Attachment E
Response to the City of Parramatta Council's key issues (SSD 8784)

**Through Site Link**

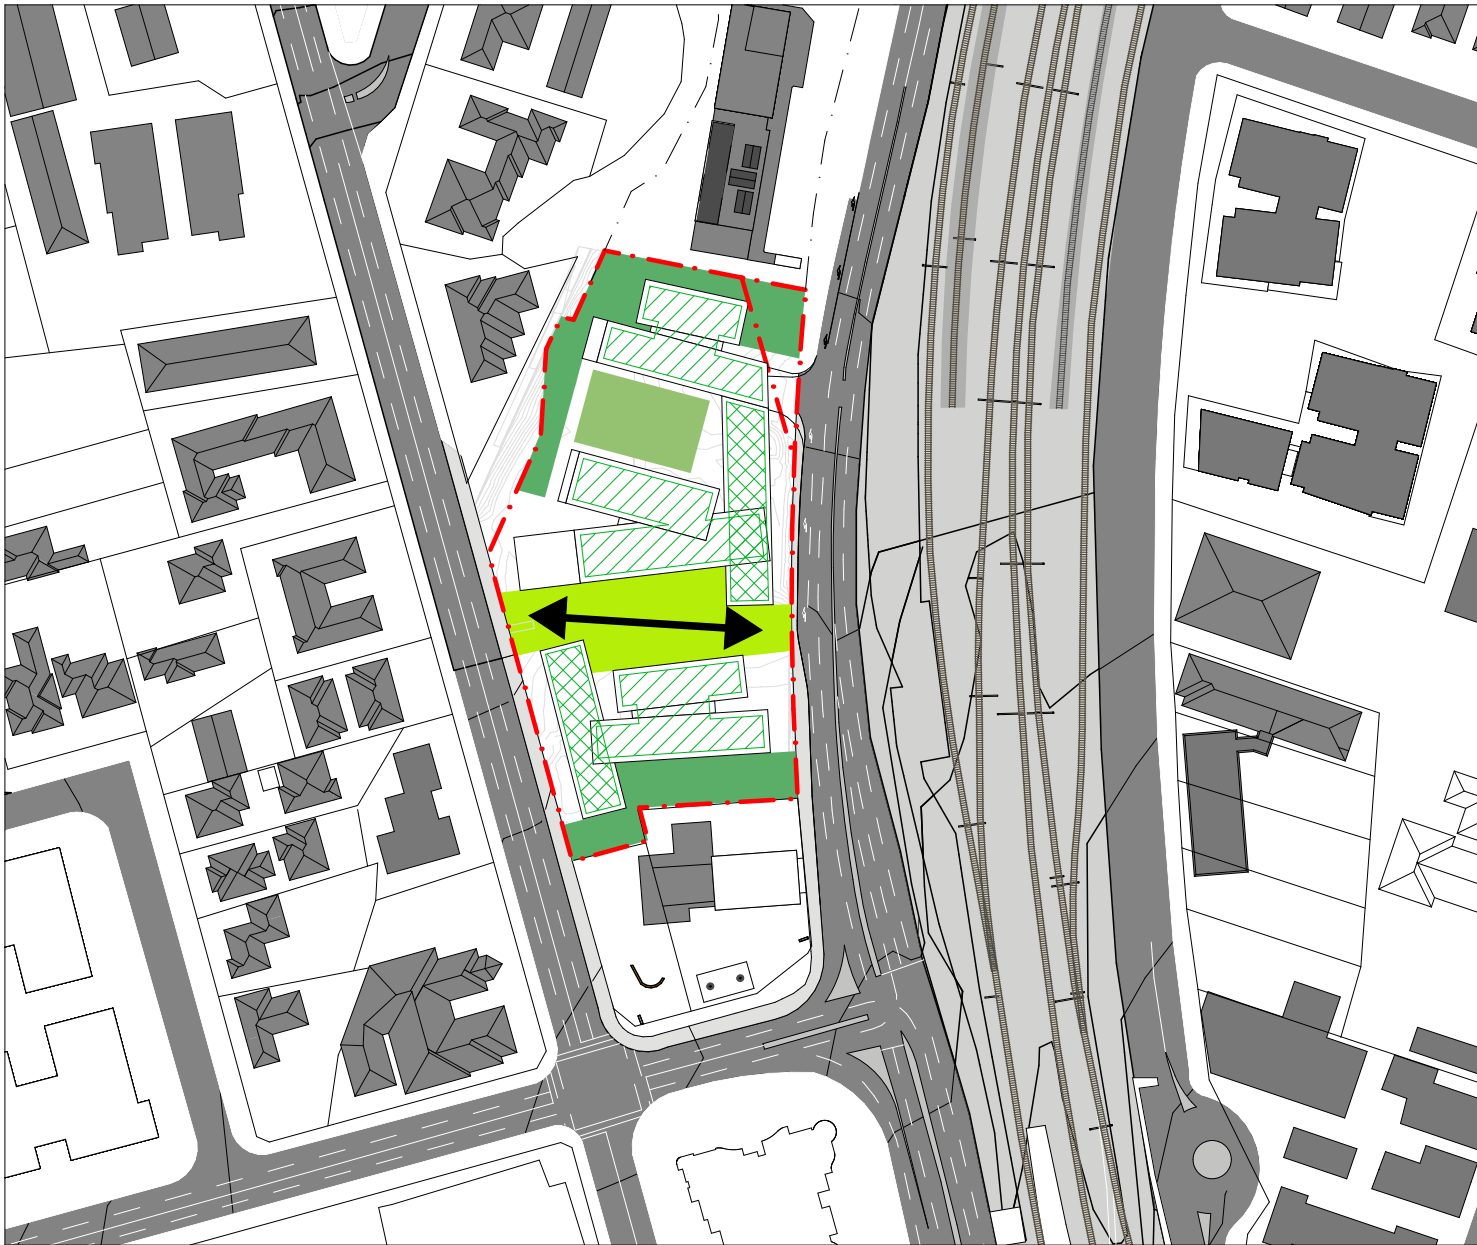
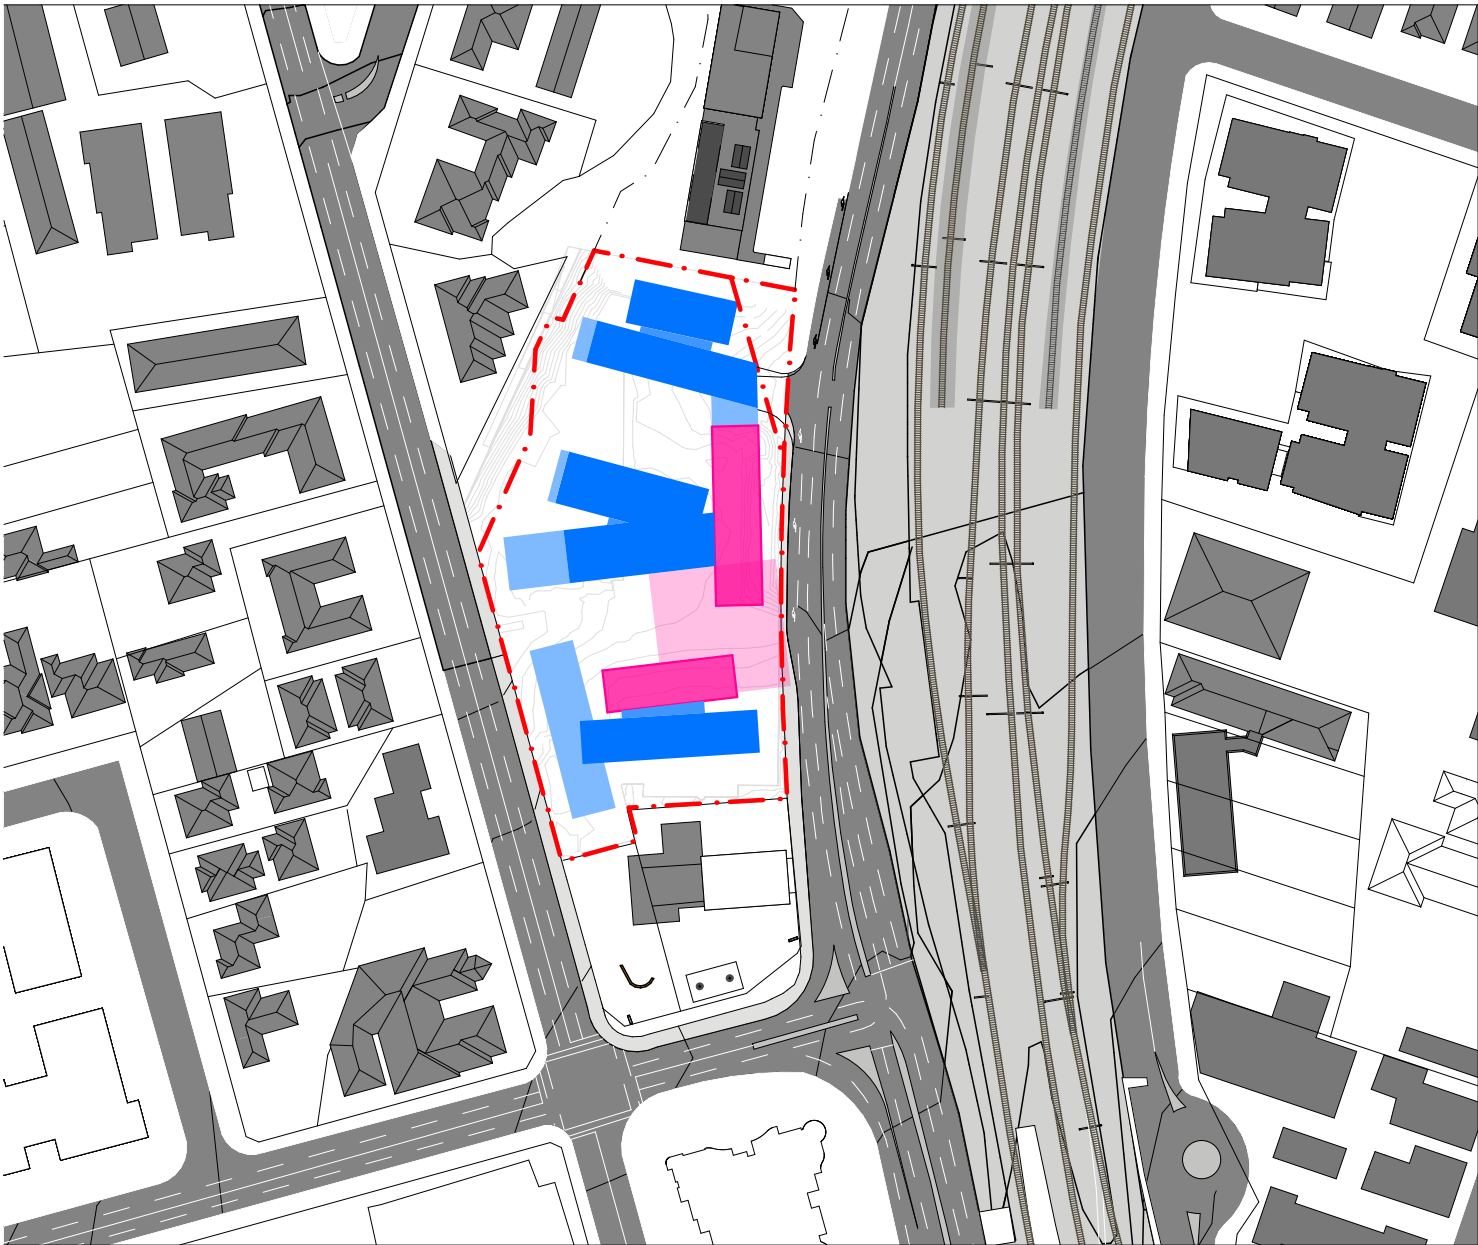
<p>3. Council's Epping Town Centre Traffic Study identified the provision of a link road through the site will take pressure of key intersections in the peak periods in the long term, coupled with a suite of traffic improvements. The traffic response contained in the application is a site focused response and does not provide adequate traffic model to support its arguments. Council requests that the link road be provided as part of the proposal.</p>	<p>The provision of a link road through the site has been addressed in the EIS and RtS documents.</p> <p>The RtS included a comprehensive review by Complete Streets on a viability of a link road through the site. The findings of the review concluded that:</p> <ul style="list-style-type: none"> • an east-west link road through the site would only result in stabilising the existing traffic and any minimal benefit will be immediately absorbed by the existing latent demand • there is the potential for road safety concerns to arise should queuing onto Beecroft Road occur from traffic queuing Ray Road end • the east-west link road through the site was previously proposed by Council to TfNSW in 2013, however, TfNSW identified that this would reduce the ability for future transit oriented development that takes advantage of the site's proximity to Epping Station, and therefore reduced reliance on private vehicle use.

Council Comment	Response
	<p>Based on the advice received from qualified traffic and transport consultant reports, Landcom is of the view that there would be no sustainable public benefit would be achieved in providing an east-west link road through the site. A through-site pedestrian link that provides open space and safe walking access through the site is found to provide positive placemaking outcomes and will facilitate east-west movement of pedestrians between Beecroft Road and Ray Road.</p>
